NORWICH TO TILBURY

EN020027

Comments on Submissions received at Deadline 7

Suffolk County Council [REDACTED]

Drawing Number:
10059280-ARC-EHR-ZZ-DR-ZZ-00432
Revision:
A

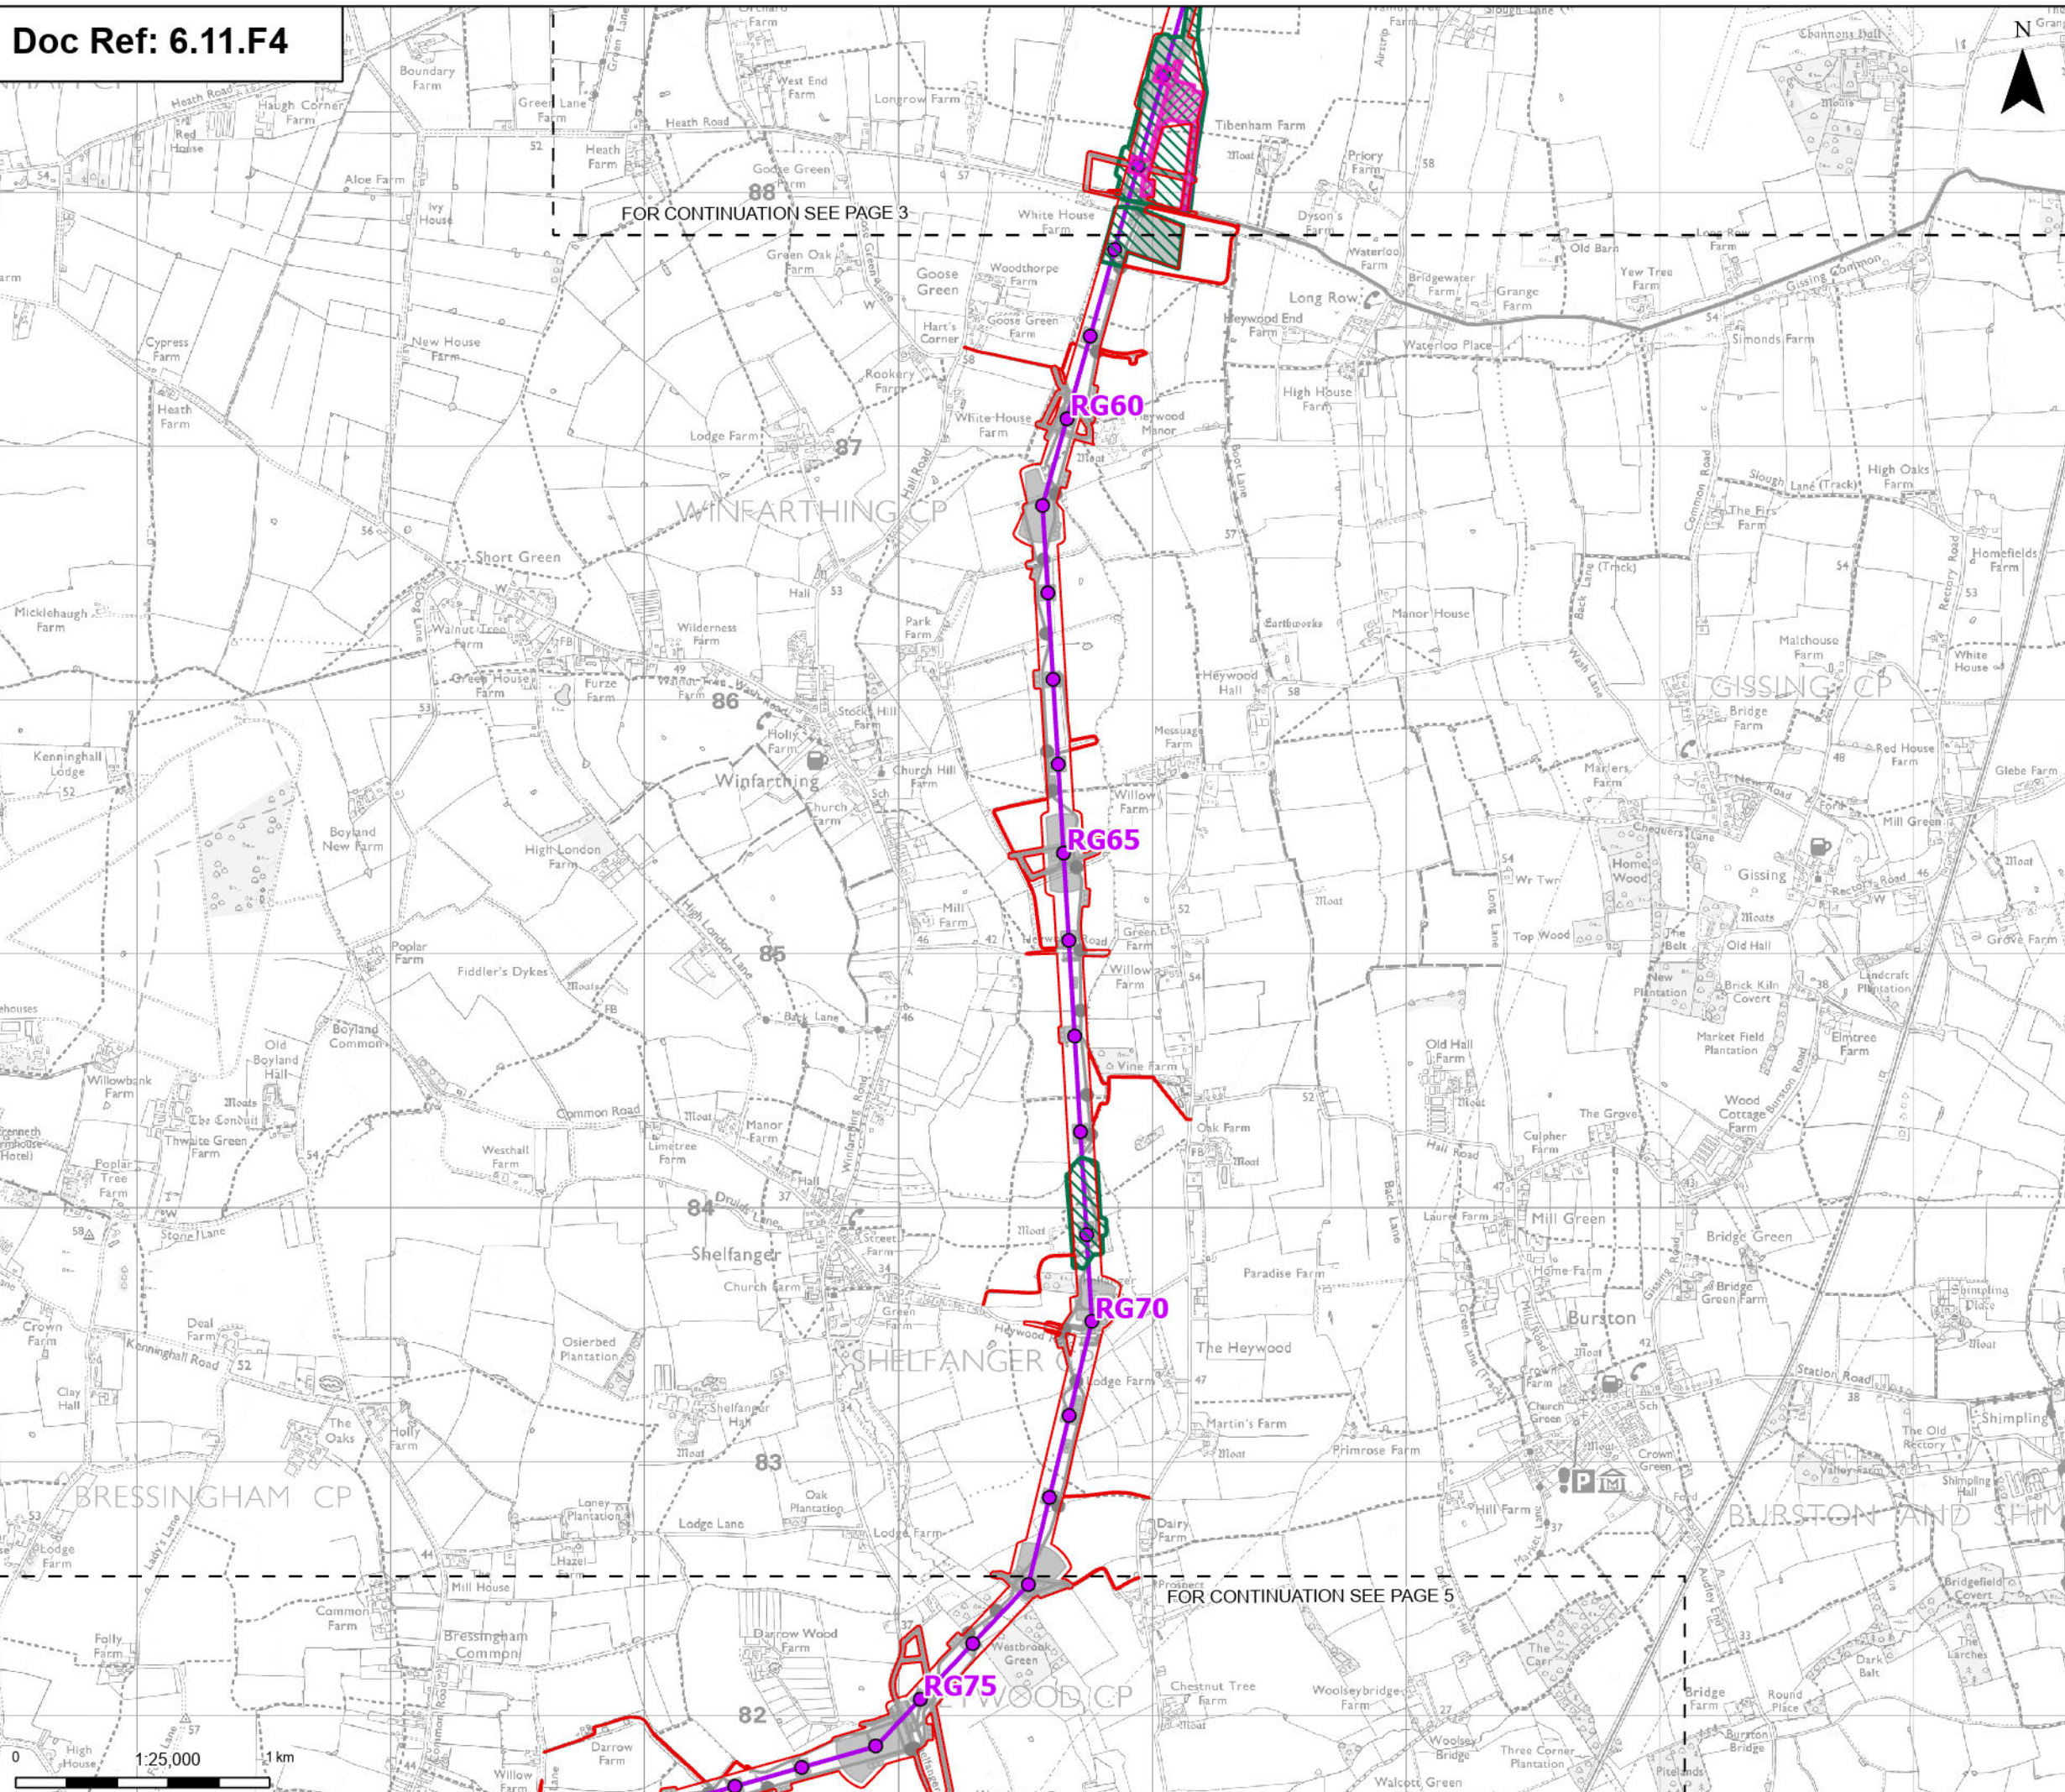
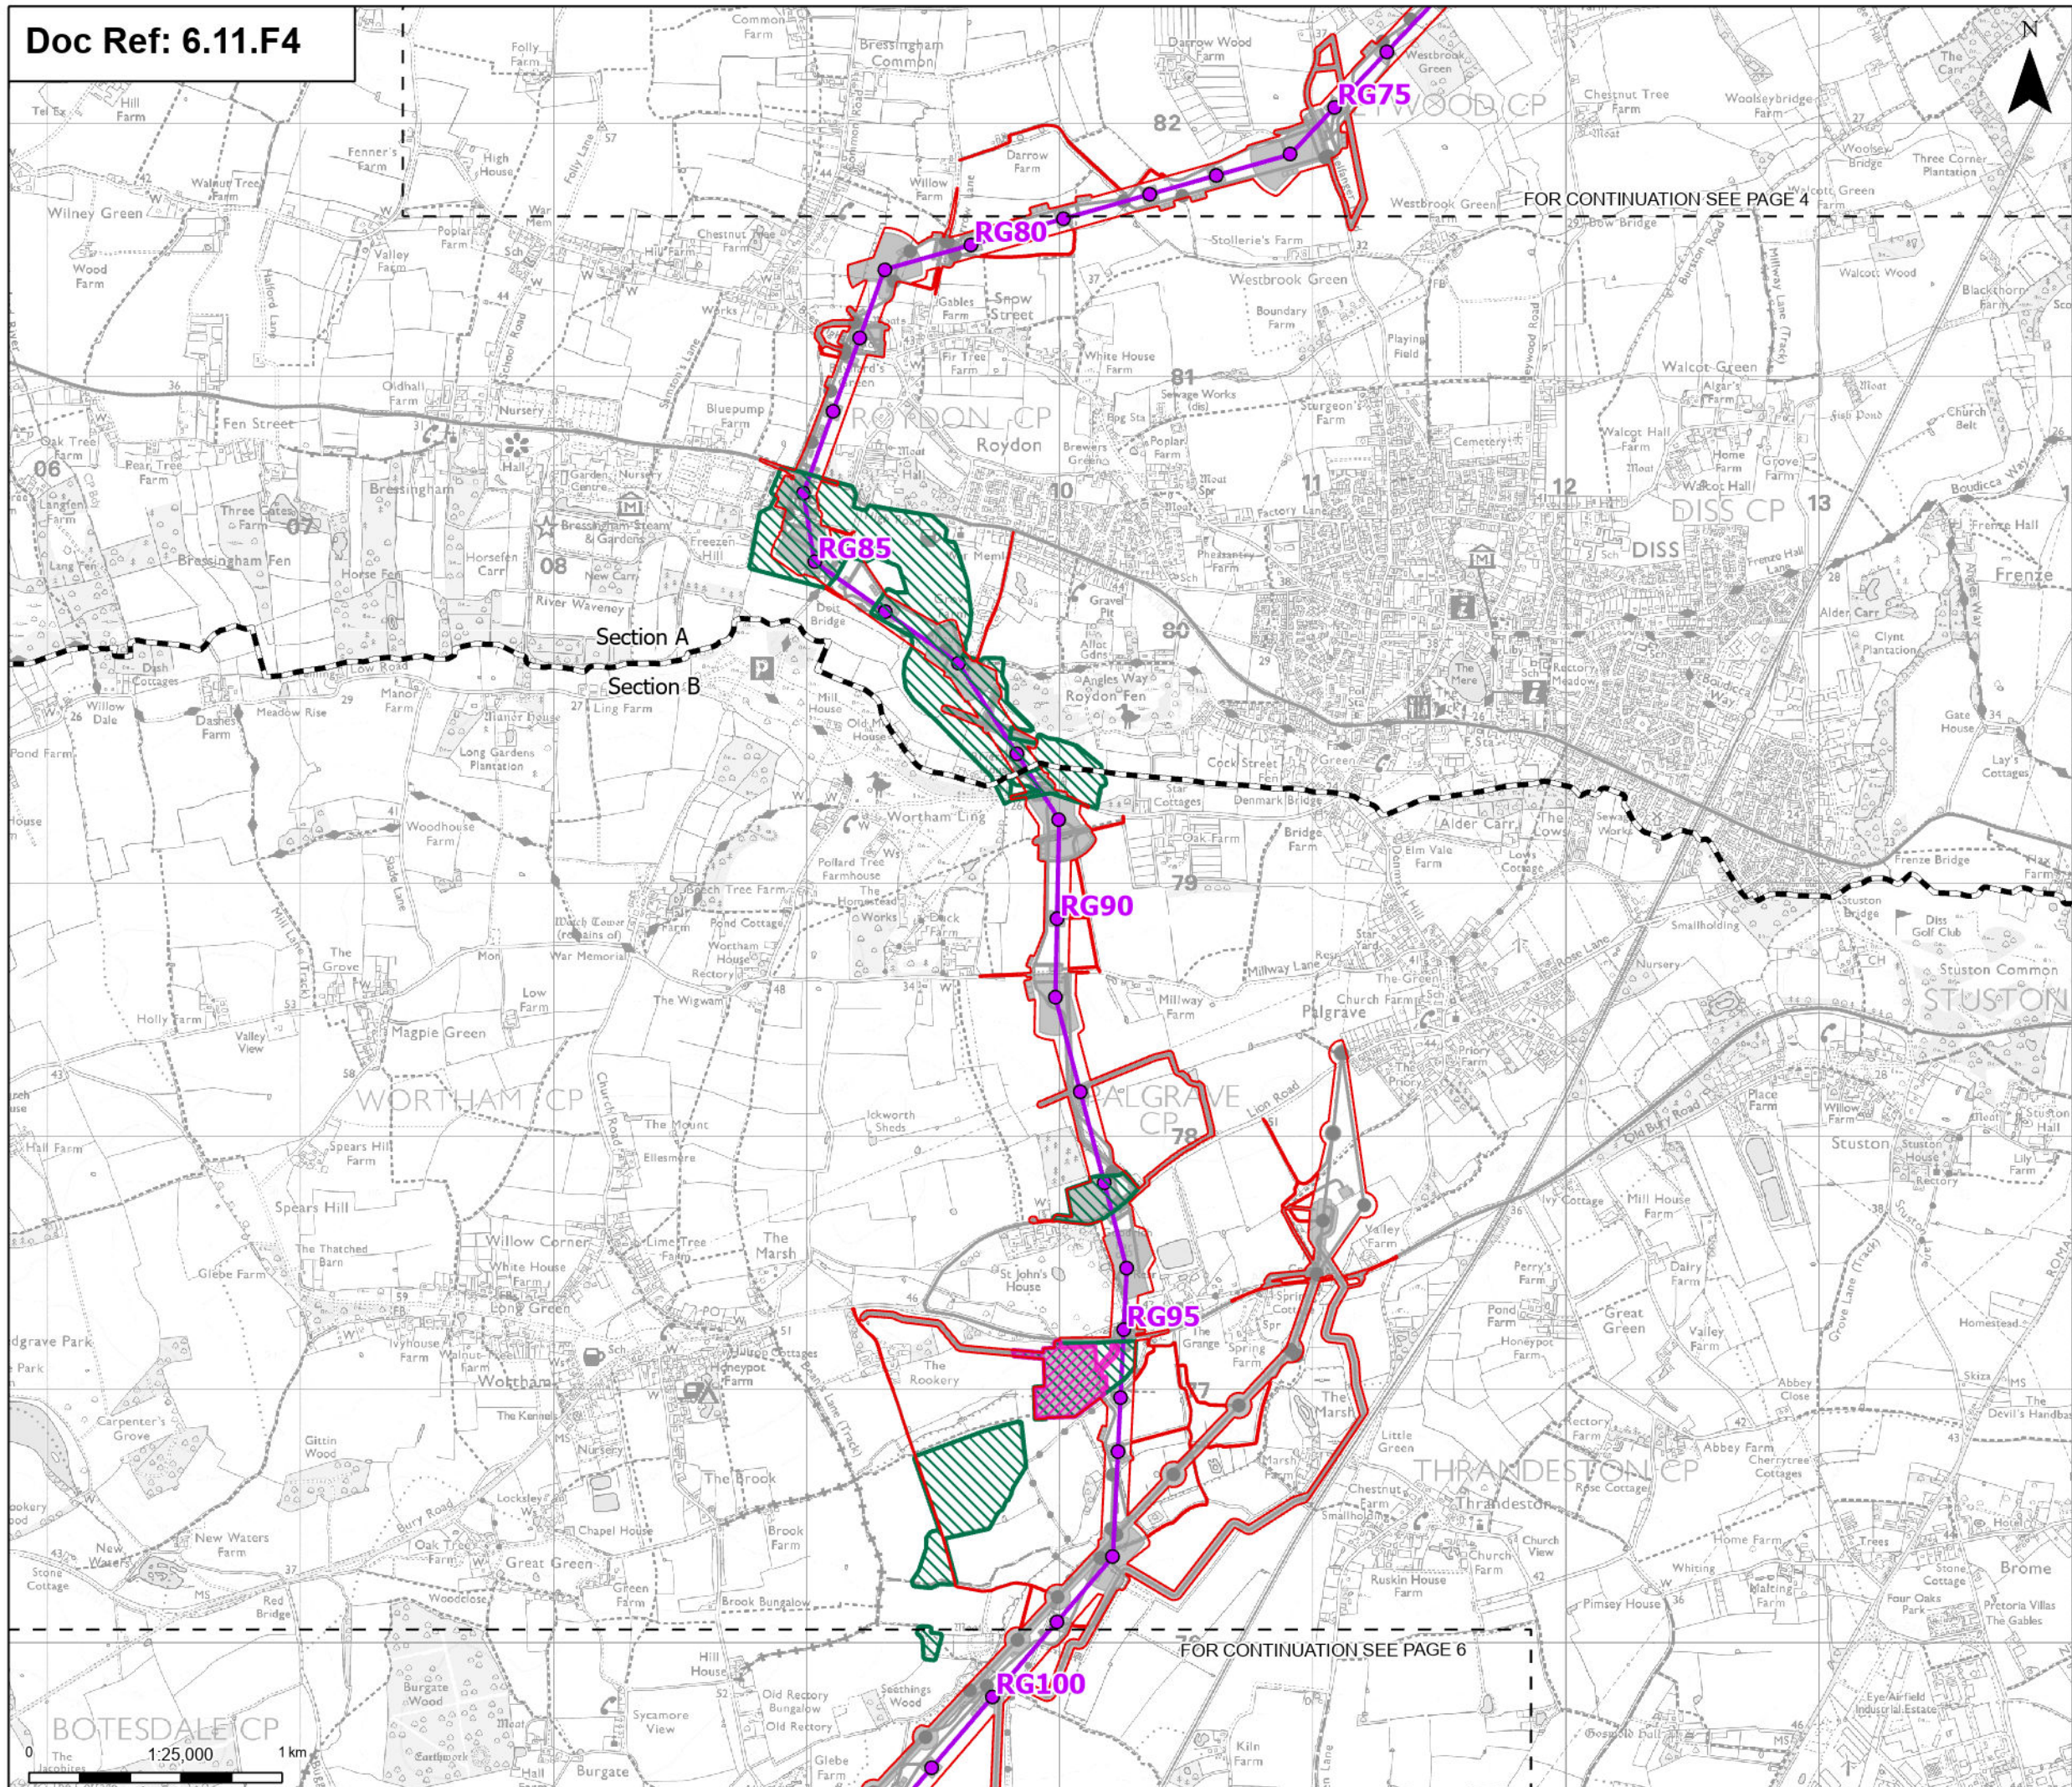
8.3	Archaeology	Figure 1 (Suffolk Sections B and C)	The title of the figure “<i>Progress of Priority geophysical survey, Priority archaeological trial trenching and Phase 2 geophysical survey and areas for Phase 2 archaeological trial trenching</i>” should be amended as follows: “<i>Progress of Priority geophysical survey, Priority archaeological trial trenching and Phase 2 geophysical survey and <u>indicative</u> areas for Phase 2 archaeological trial trenching</i>” SCCAS believe that all permanent accesses, SuDs ponds, 3rd party undergrounding of 132kV and 33kV should be depicted on the plan as requiring further archaeological assessment, evaluation and potential archaeological mitigation. Because these aspects of the scheme have the potential to seriously impact buried archaeological remains. Pulling areas should be highlighted as areas of potential construction impact to be informed by final design.

Figure 2a: Mitigation Areas ~~102a and 102b~~102 a&b over Trial Trench Locations

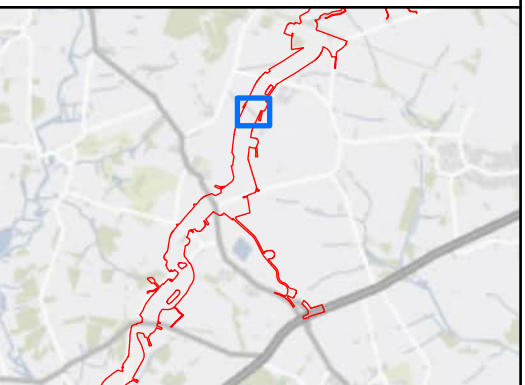
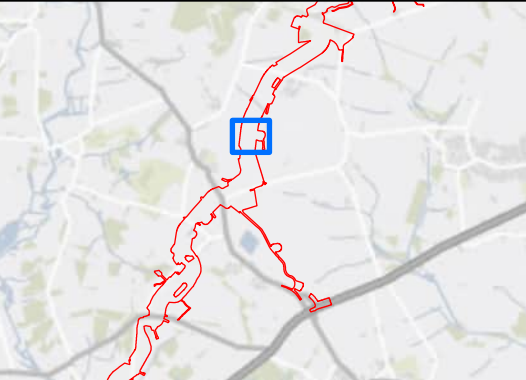
8.4	Archaeology	Figure 2 (Suffolk Sections B and C)	The proposed priority area mitigation areas should reflect the priority area mitigation areas recommended by SCCAS in an email to the Applicant on 24 July 2026, see below: NB. Phase 2 trial trenching and any further trial trenching of areas of impact post-consent has not been completed, and further archaeological mitigation will be informed by the results of this programme of further evaluation.
8.5	Archaeology	Mitigation areas Site 007	There is very little separation between the proposed targeted mitigation area around the ditch containing Iron Age pottery and the larger mitigation area. SCCAS therefore recommends that the two areas are combined, as shown in green on the plan below. This would make the stripping strategy more straightforward and reduce the likelihood that extensions will be required during the fieldwork.

SCCAS has not suggested that the medieval and prehistoric remains are directly or indirectly related. However, archaeological sites are frequently multiperiod, with activity of different dates occurring within the same geographical area. The mitigation area should therefore reflect the multiperiod character of the archaeological remains identified at Site 007 rather than being defined by reference to a single period.
